Recommendation Report for Planning Permission for Works or Extension to a Dwelling

REF NO: LU/254/21/HH

LOCATION: 17 Peregrine Road
Littlehampton
BN17 6DT

PROPOSAL: Erection of two storey rear extension, single storey side extension to create garage and single storey front porch extension following the demolition of existing garage

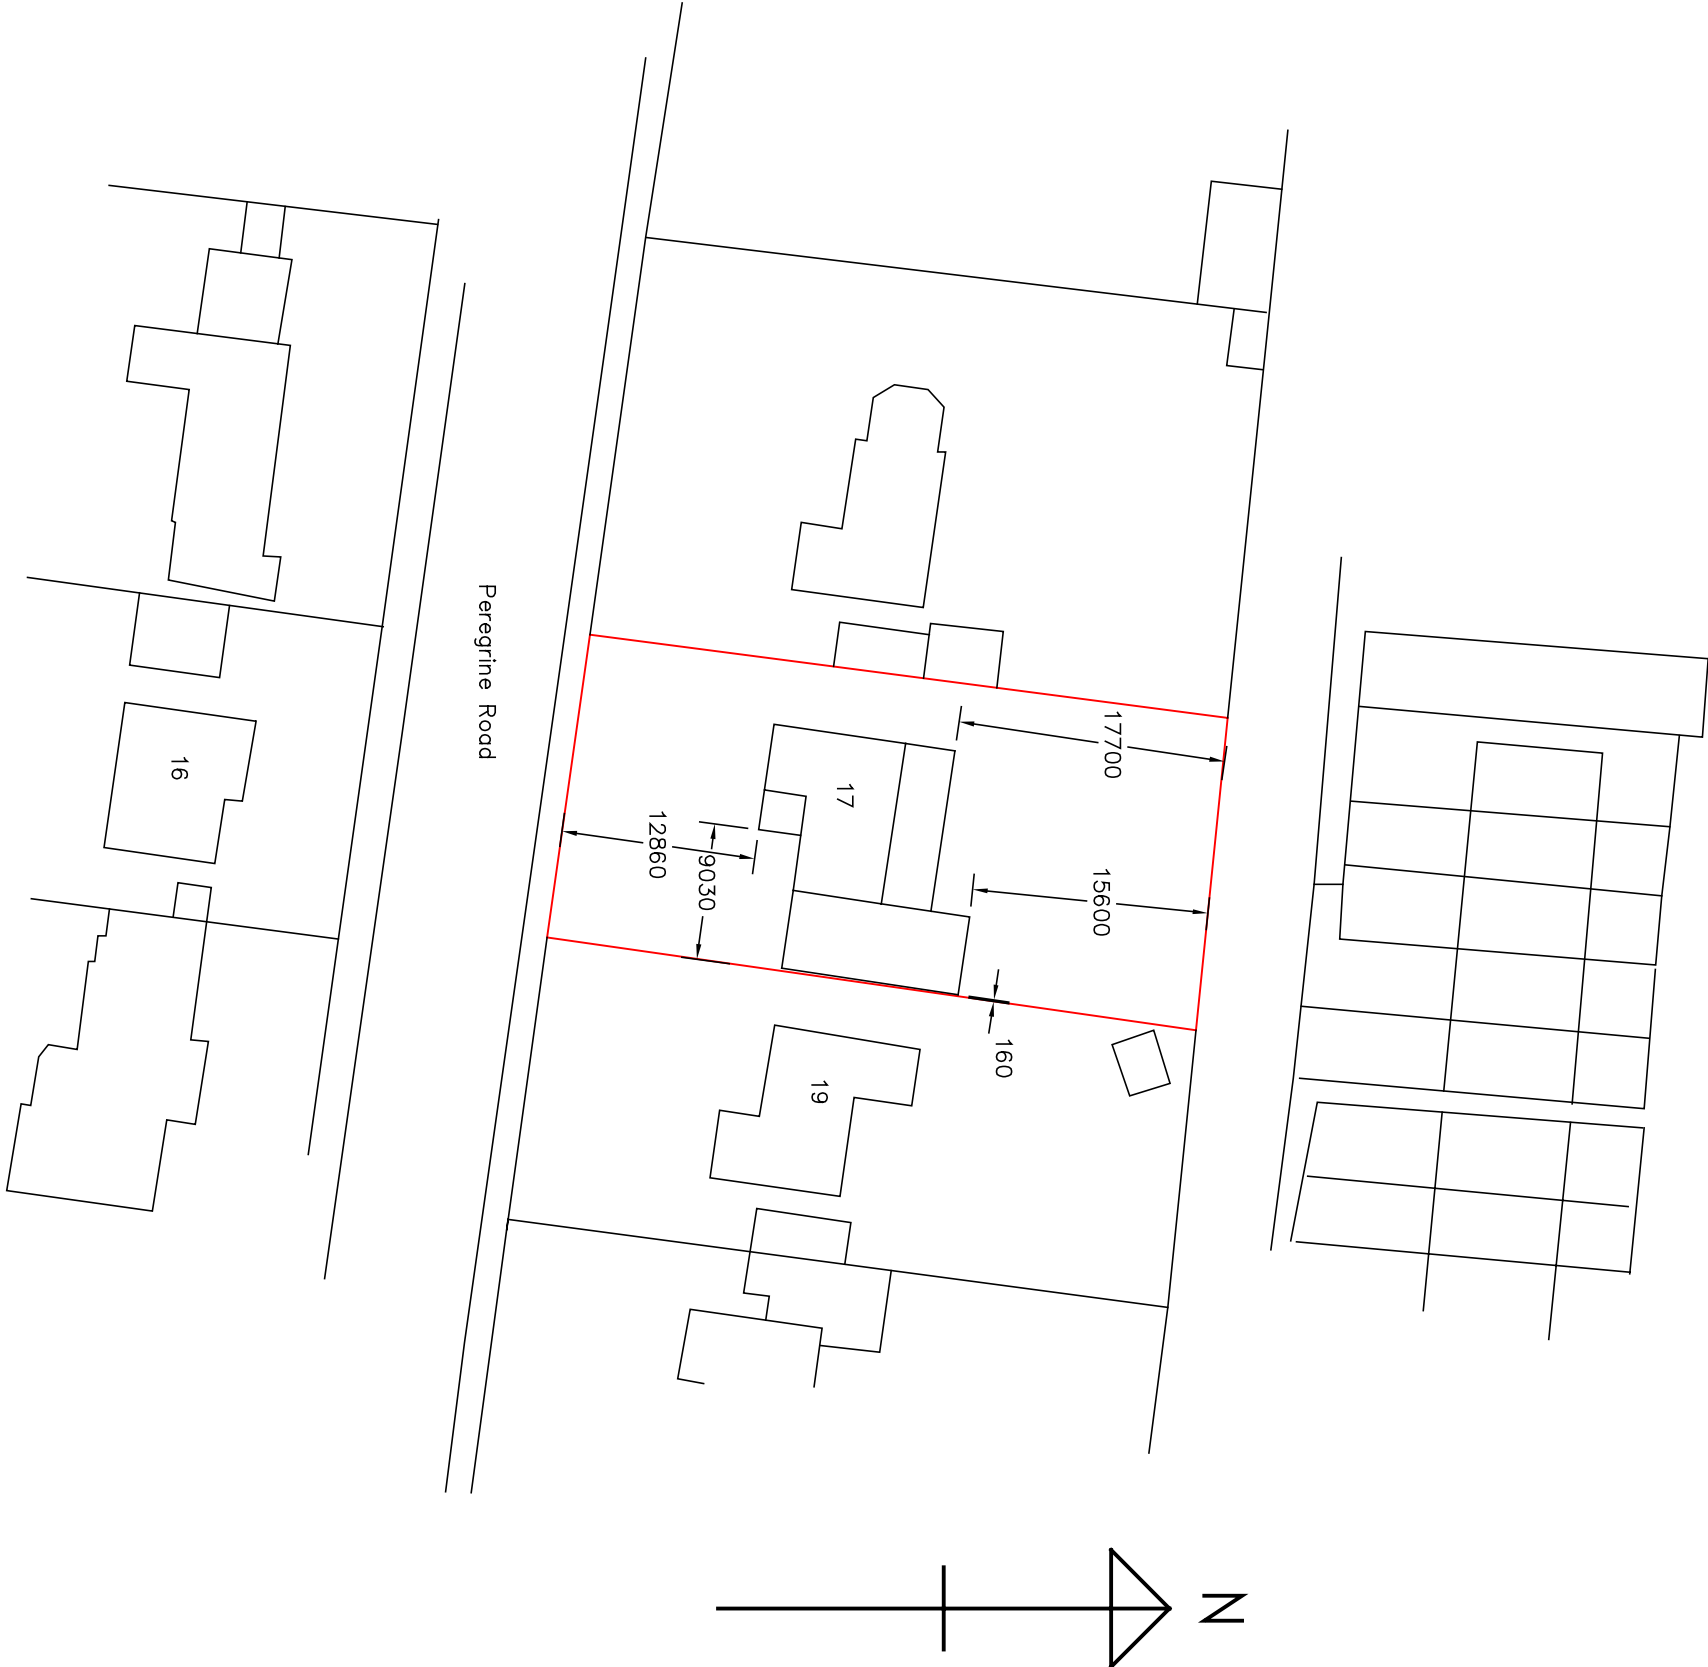
An attached garage to the west will be removed and will be replaced with a garage which will run along the eastern boundary. This will have a pitched roof and is large however with it set back approximately 15m from the front boundary, the addition will not appear unduly dominant upon the street scene.

A two storey extension will be constructed along the rear elevation. This has a depth 3.3m. It will have a height of 5.5m with a hipped roof located just above the eaves, set below that of the ridge height. 4.3m will be retained to the western boundary and 5.45m to the east. A result of the separation retained, the extension is not considered to result in adverse overbearing or overshadowing and does not intersect a 45 degree angle from the closest neighbouring windows.

2681/02/02

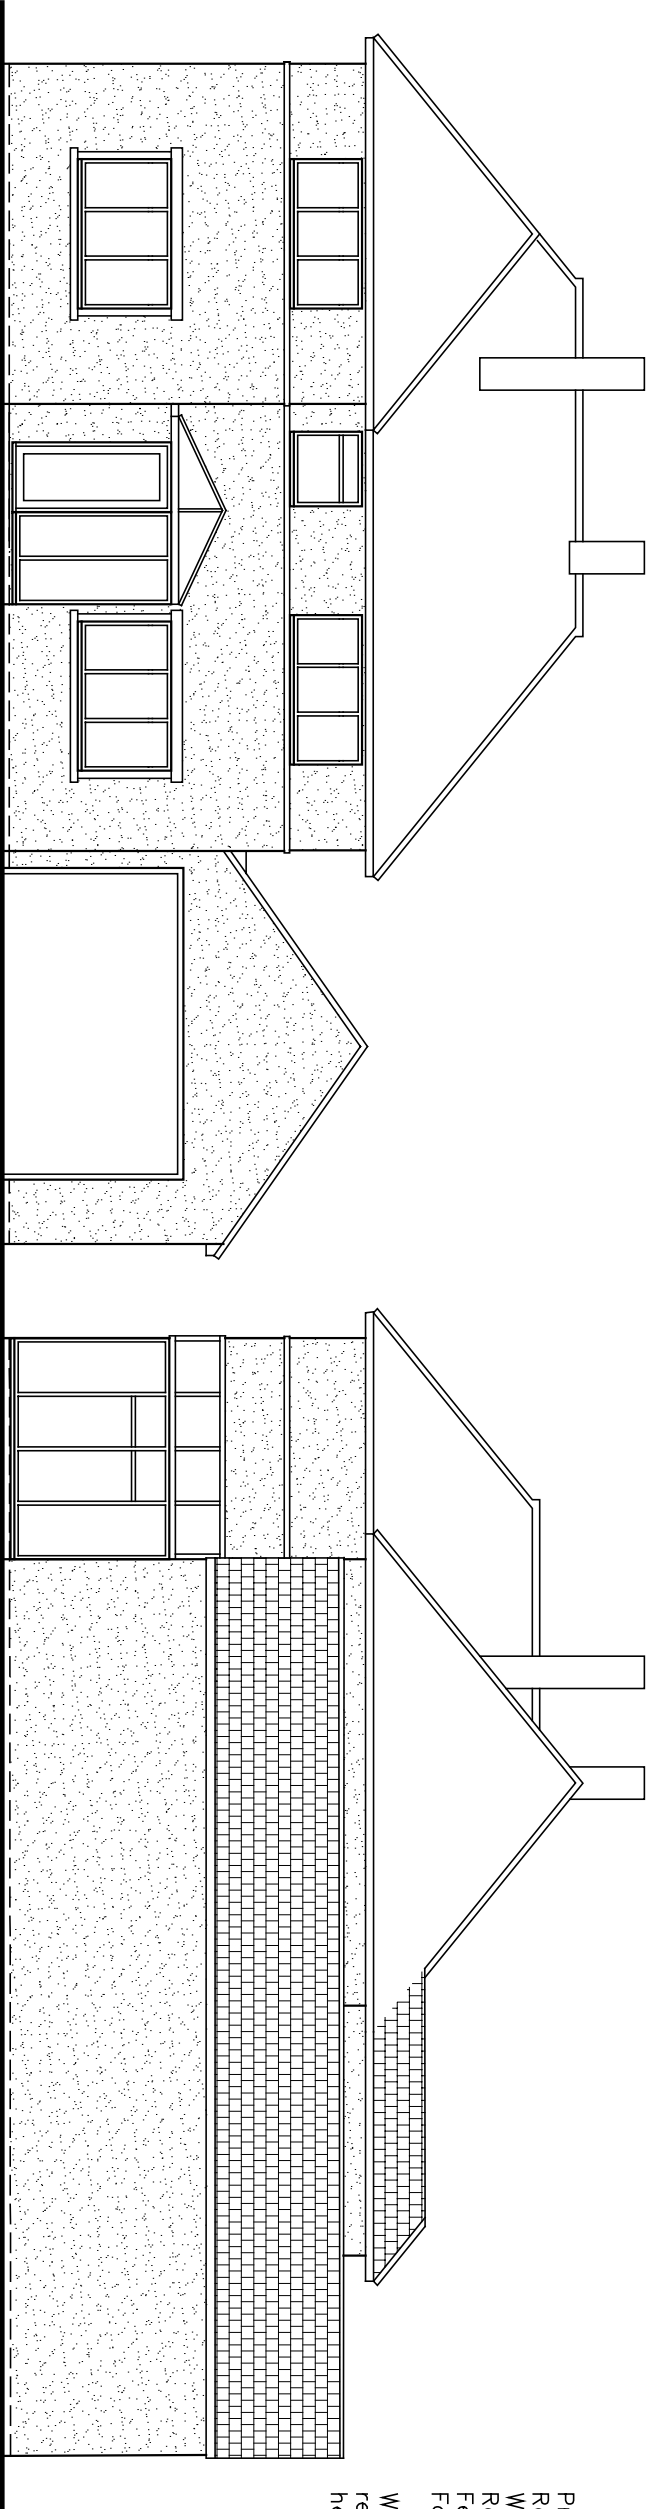
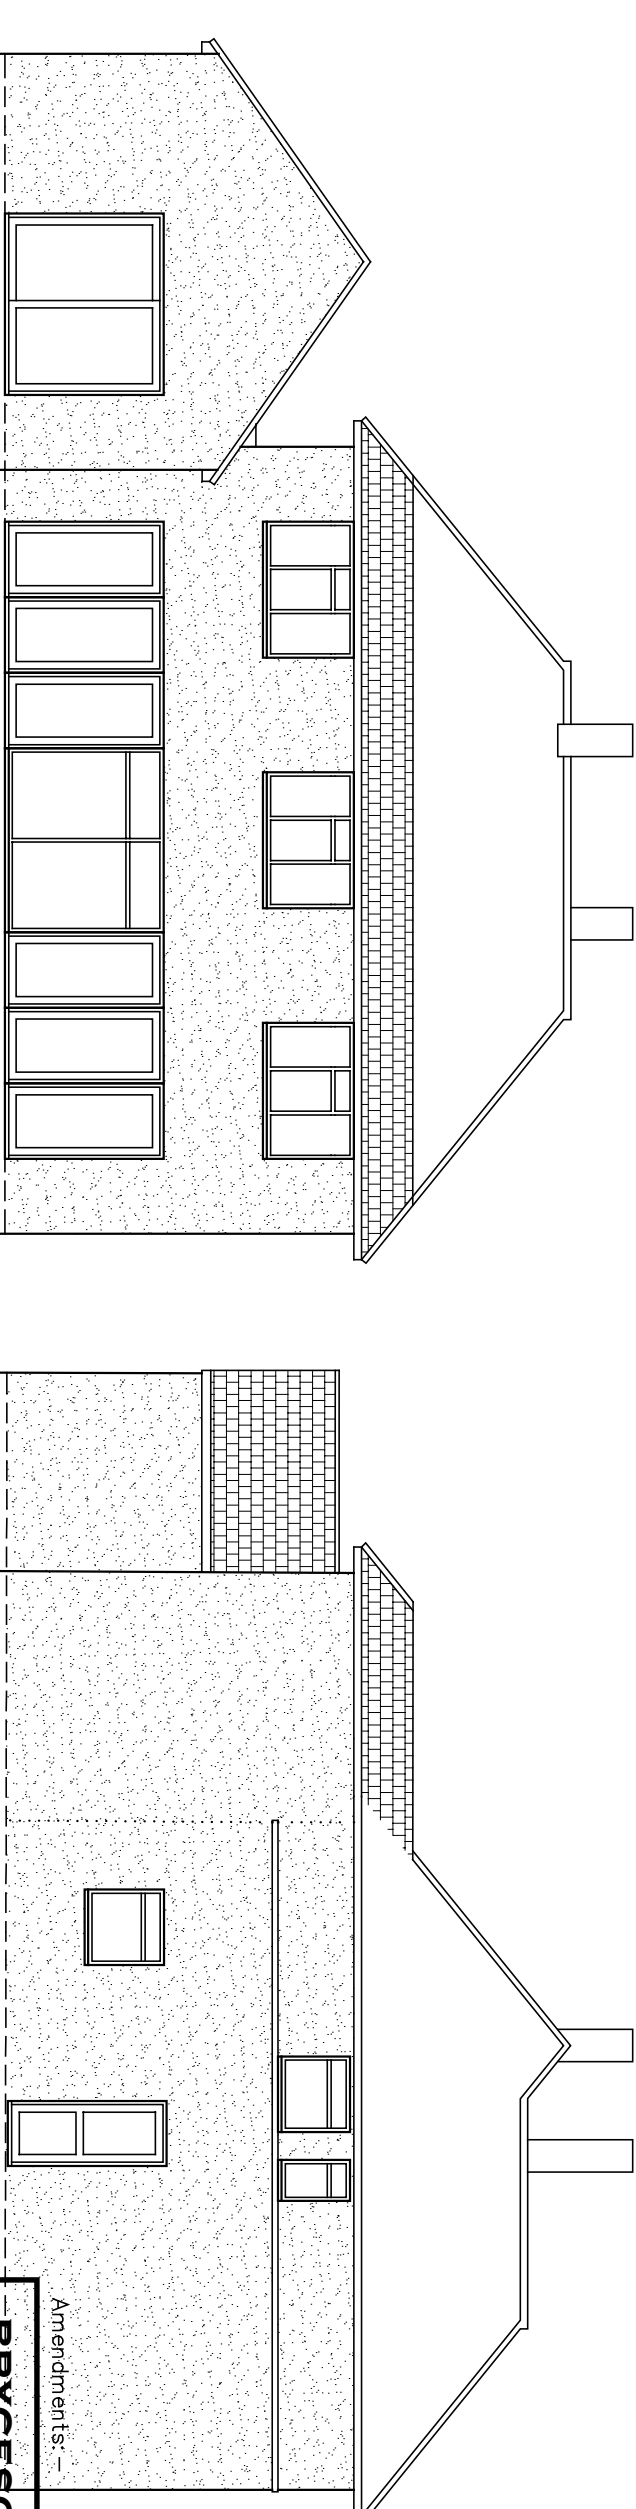
The property is an L shape with a two storey gable front. There will be porch infill. This will have a depth of 2.85m, width of 2.55m and height of 3m, although does not extend beyond the principle elevation. It will have a pitched roof and appears well integrated with the host dwelling.

The garage will join with the eastern elevation and extends to a length of 12m, which extends around 2.6m beyond the proposed rear elevation. This has a width of 5.25m and a pitched roof to a height 4.5m with eaves to 2.9m.

The property at No 19 has a conservatory to the rear western side and the garage will extend beyond this by around 2m. It may give rise to some overbearing due to the height, however there is planting along the boundary which should help to restrict views and with 3.7m retained from the boundary to the side elevation of No.19, it is not considered impacts will be significant.

There will be 3 first floor rear facing windows. These replace existing albeit located further in depth to the north. They are not considered to result in adverse views, with views over neighbouring gardens limited

due to the siting of the properties and 17m is retained to the rear boundary. Ground floor windows and doors to the rear of the garage will overlook the garden of the host dwelling and there are no side facing windows proposed.
